From: Simon Davis
Sent: 08 February 2019 10:36
To: Planning.Responses
Subject: FW: Y/102/18/DOC (Condition 13 Construction Management Plan)
Attachments: Construction Management Plan - Land South of Burndell Road.pdf; Appendix A - Construction Traffic Plan Rev B.pdf; Appendix A - Site Heras Fencing Layout Rev B.pdf; Appendix A - YAPT-SC-001 Rev B.pdf

From: James Hammond [REDACTED]
Sent: 06 February 2019 18:01
To: Simon Davis [REDACTED]
Cc: Ralph Chakadya [REDACTED]
Subject: RE: Y/102/18/DOC (Condition 13 Construction Management Plan)

DRAWING TITLE:
 BUILD SEQUENCE DRAFT

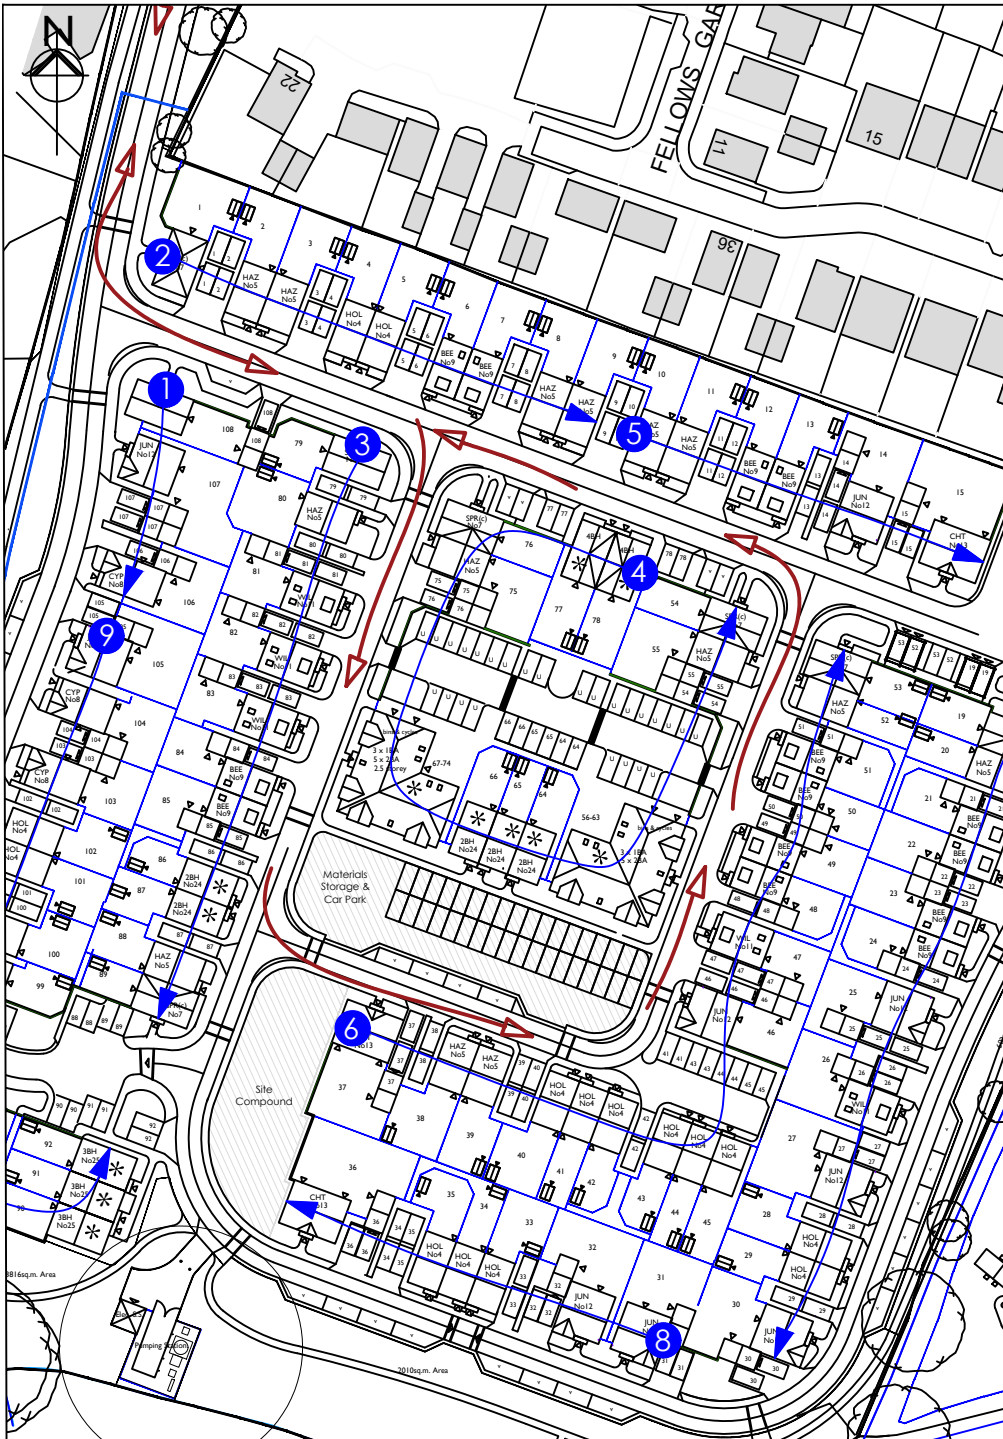
Also, whilst I see that the Appendix A Site Heras Fencing Layout has been amended with the set back annotation, the plan reference remains the same. Can you update the Revision number to Rev B – and also ensure that any other amended documents are given a revision number or amended date. This means that we can then correctly reference the correct plan on the decision letter. Thanks

- The heras fencing drawing has now got Rev B noted on it.
- The compound layout (YAPT-SC-001 Rev B) has been updated to show the double stacking of units for materials. Rev B is also noted on the drawing.
- The construction traffic plan has also been updated to Rev B (noted within the title).
- The CMP has had the date amended within it.

Please find attached amended CEMP details for the above application. As advised, the gates are now setback a minimum 5m from the highway. I trust the amended details would allow you to progress the application to a positive determination. If you have any further queries please do contact me. Thank you.

DRAWING NUMBER: YAPT-SC-001 REV: B

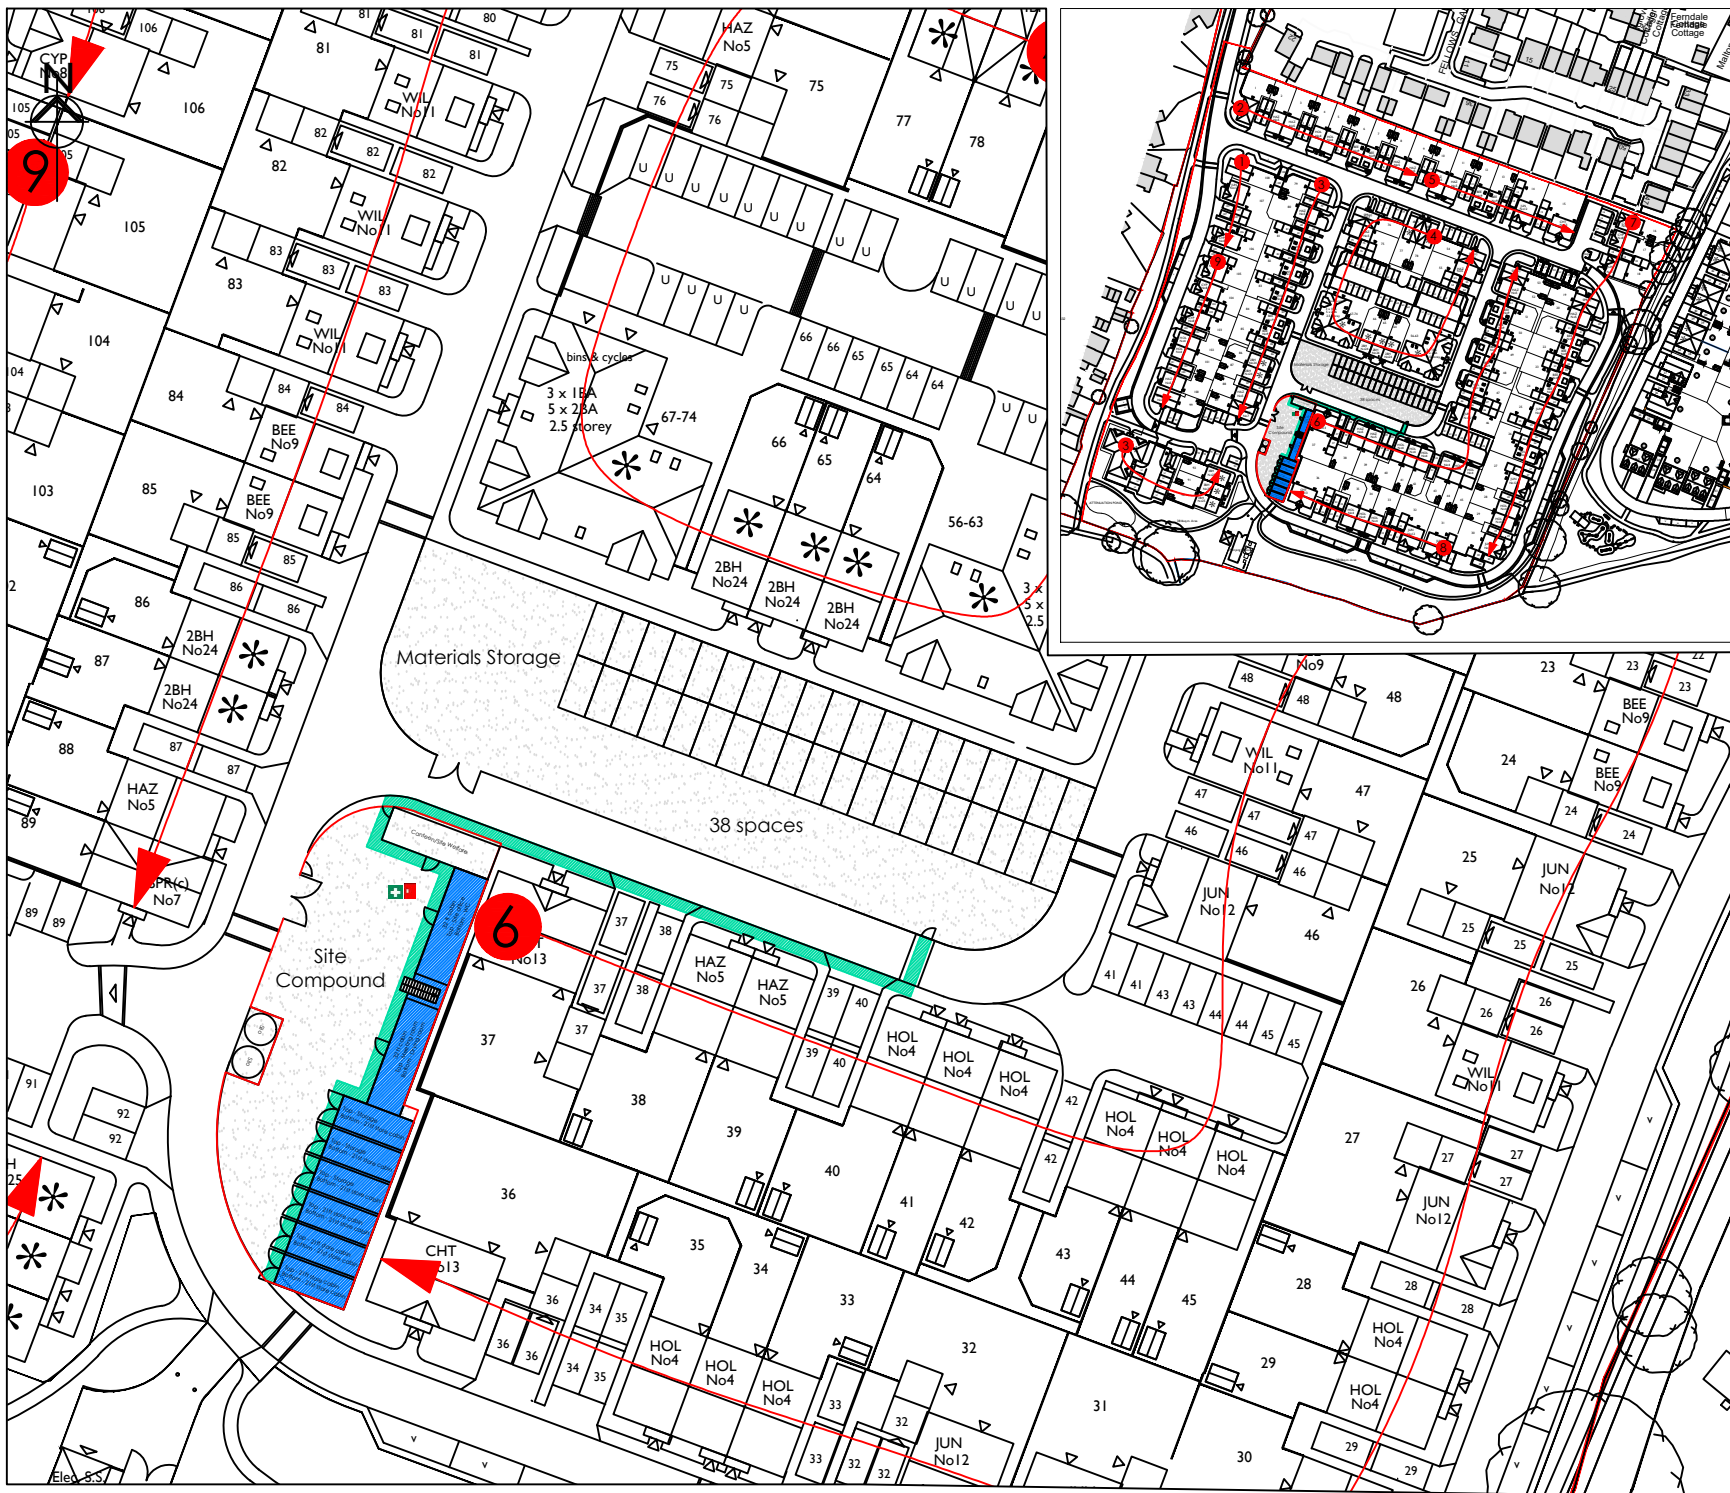
Can you advise which of the 5 additional documents/plans submitted have been amended? You only need to send me those which have been amended, otherwise I am not sure which to replace on our system.
